**Heyford Park, Camp Road, Upper Heyford,  
Bicester, OX25 5HD**

**23/01959/NMA**

**Proposal:** Non-material amendment to 16/02446/F - amended elevation plans for 7 plots (plots 630-632, 634-635 & 646-647)

Drawing Title:  
**HOUSE TYPE DL2v2  
ELEVATIONS**

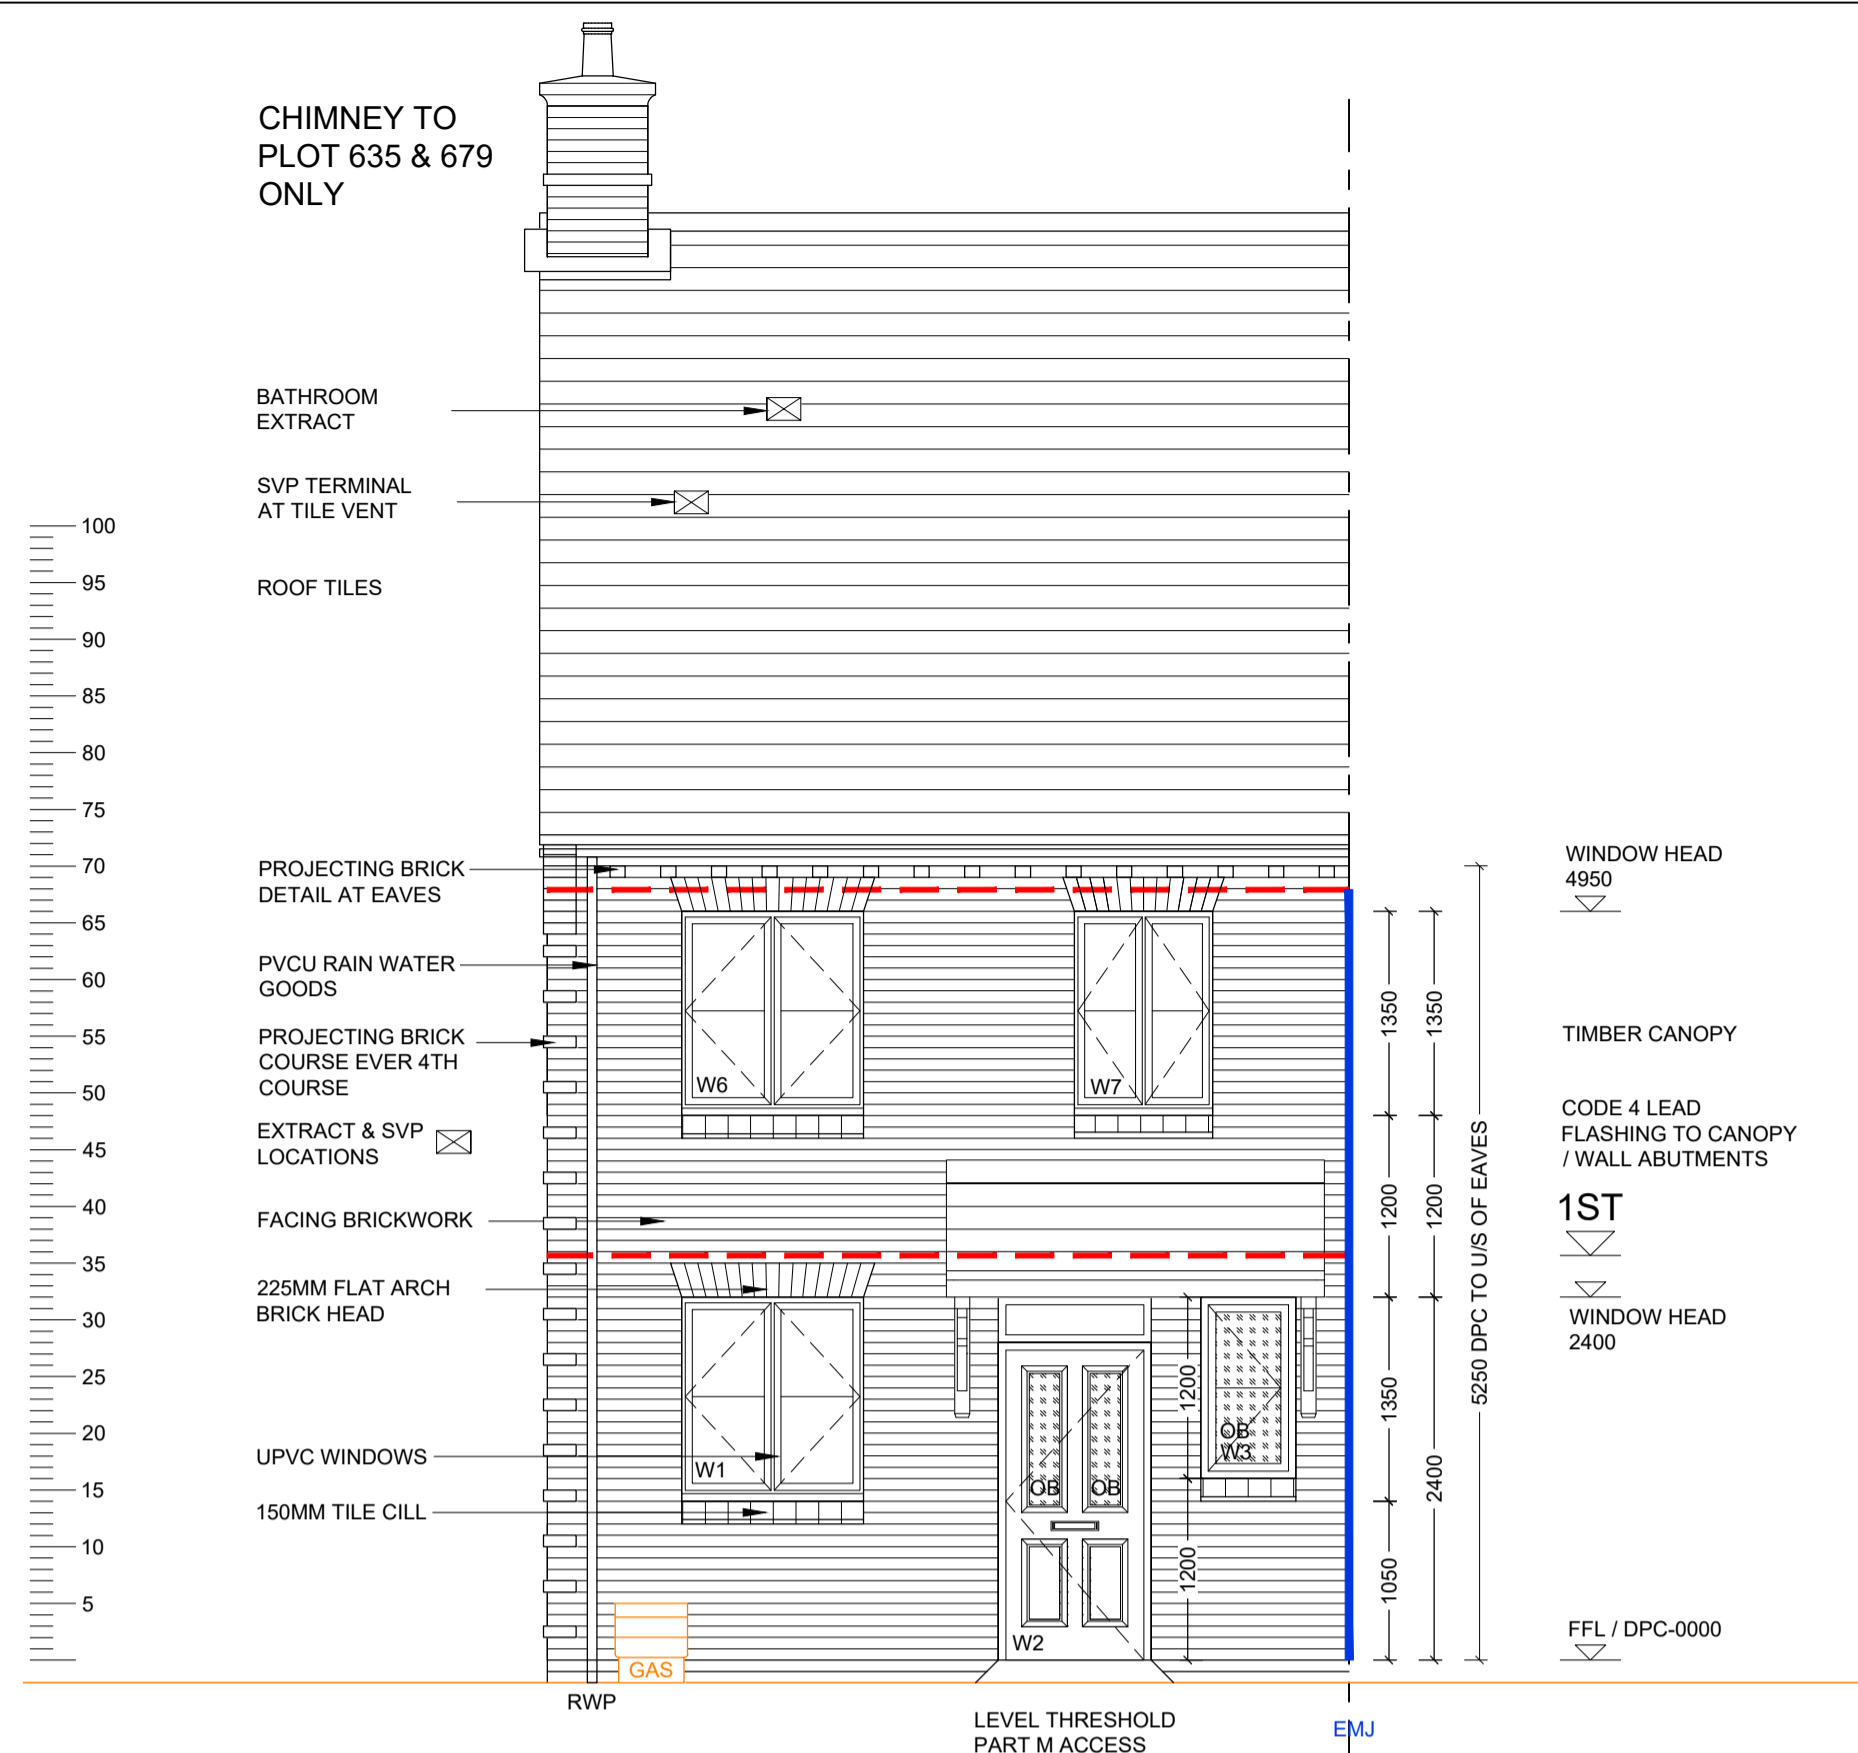
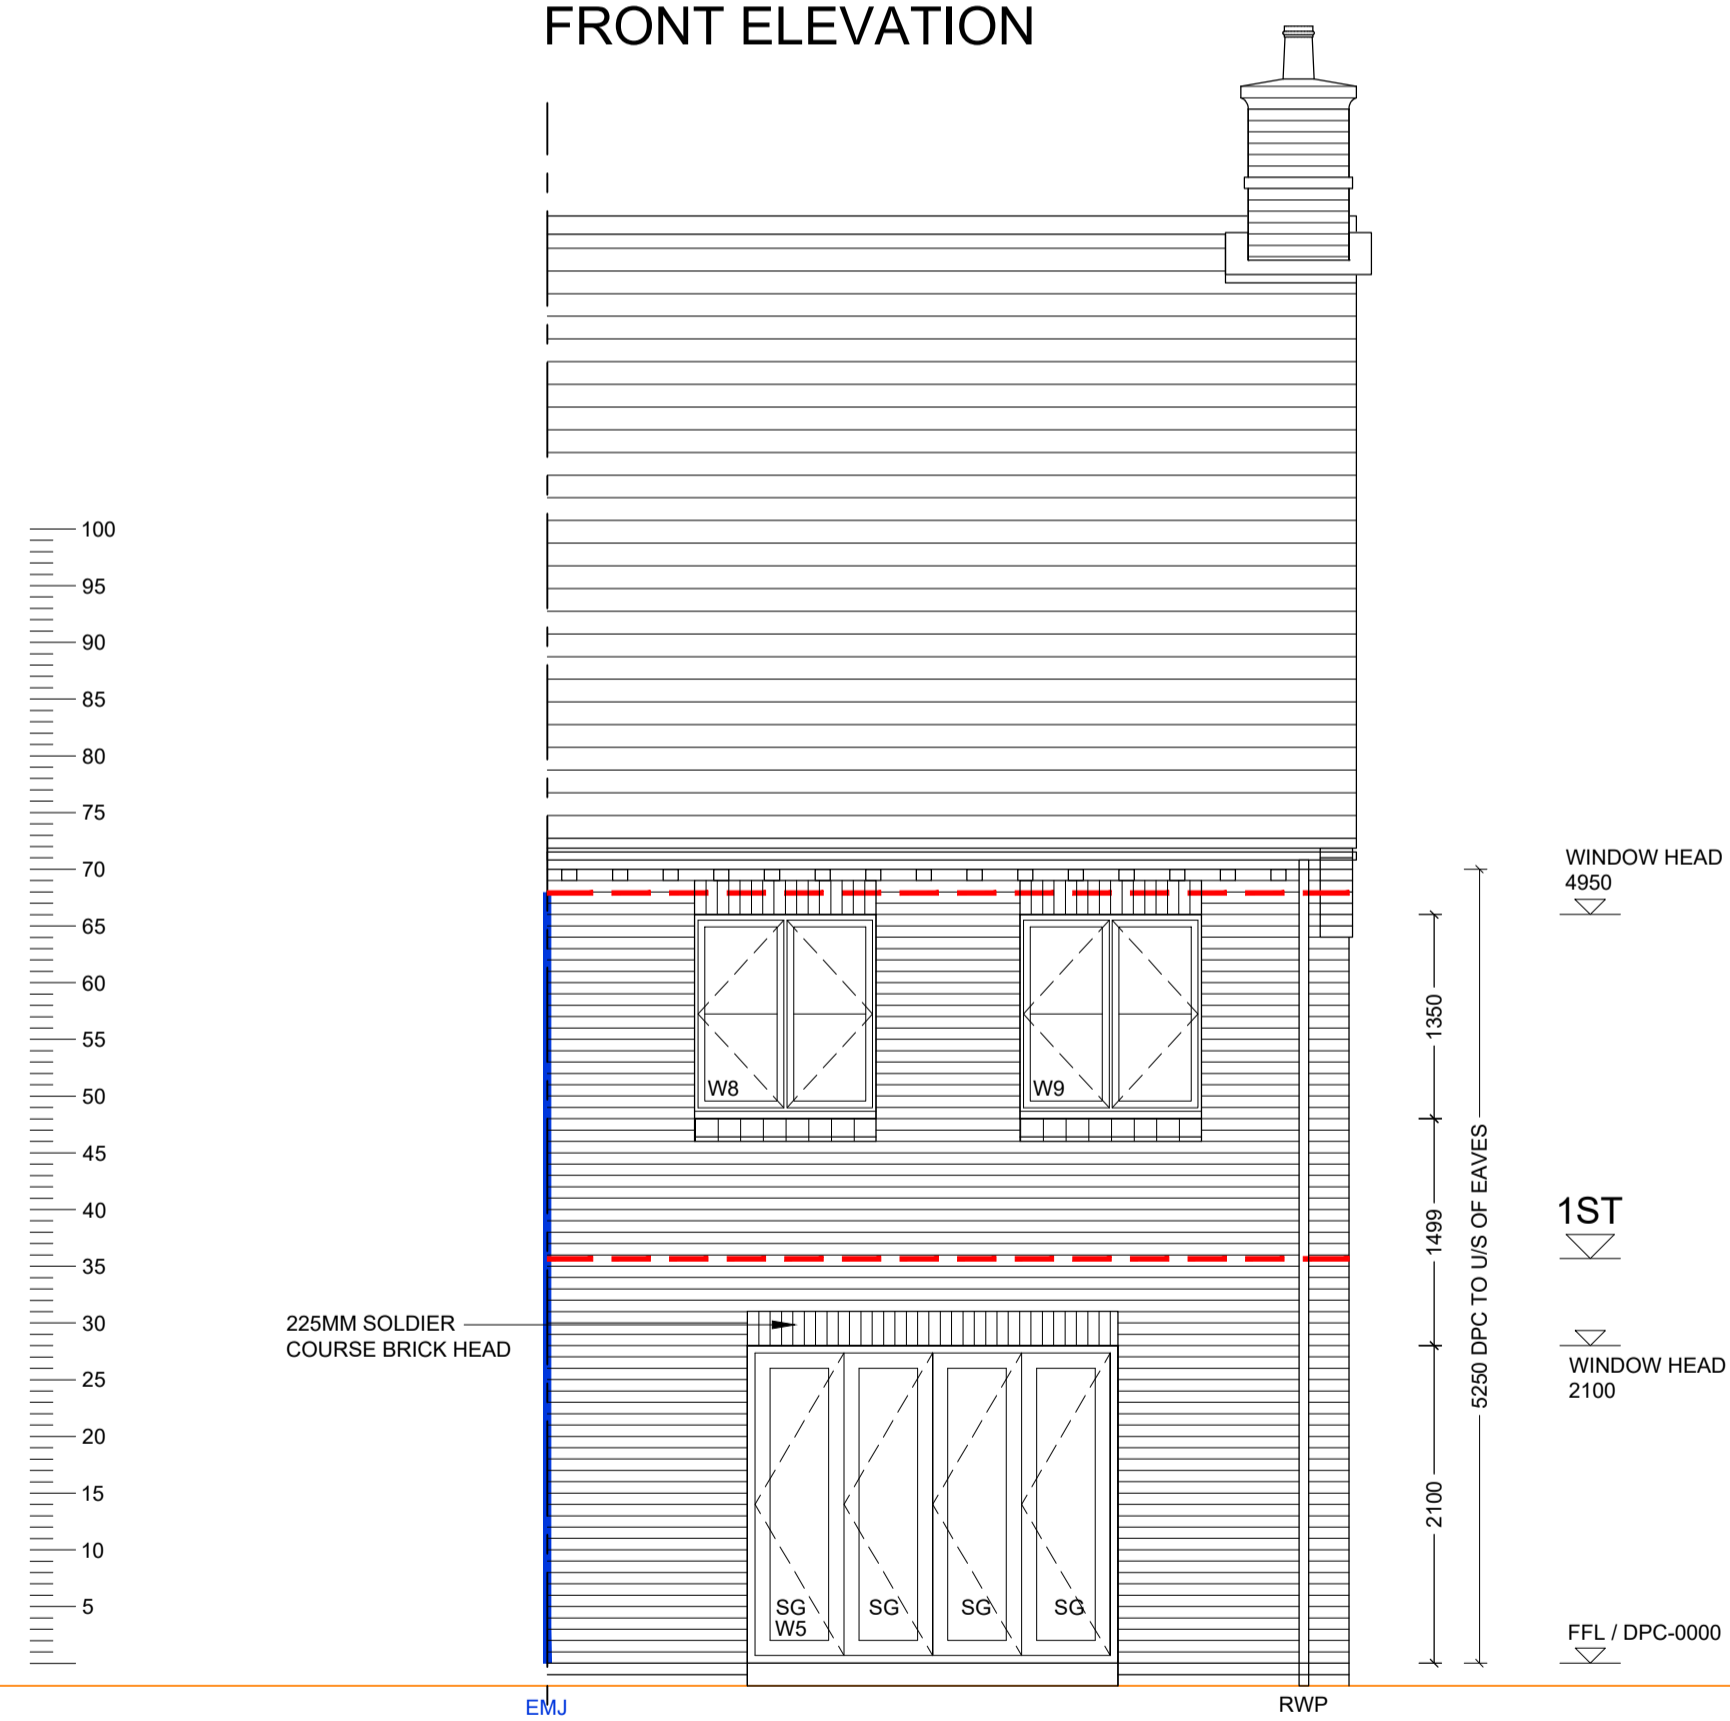
### House Type DL2v2 – Plot nos.634 and 635

- Bay window added to plot 634;
- Fanlight added above front door;
- Windows increased in height;

- Brick quoin detail added to front elevation corners;
- Stone detailing replaced with flat brick arches.
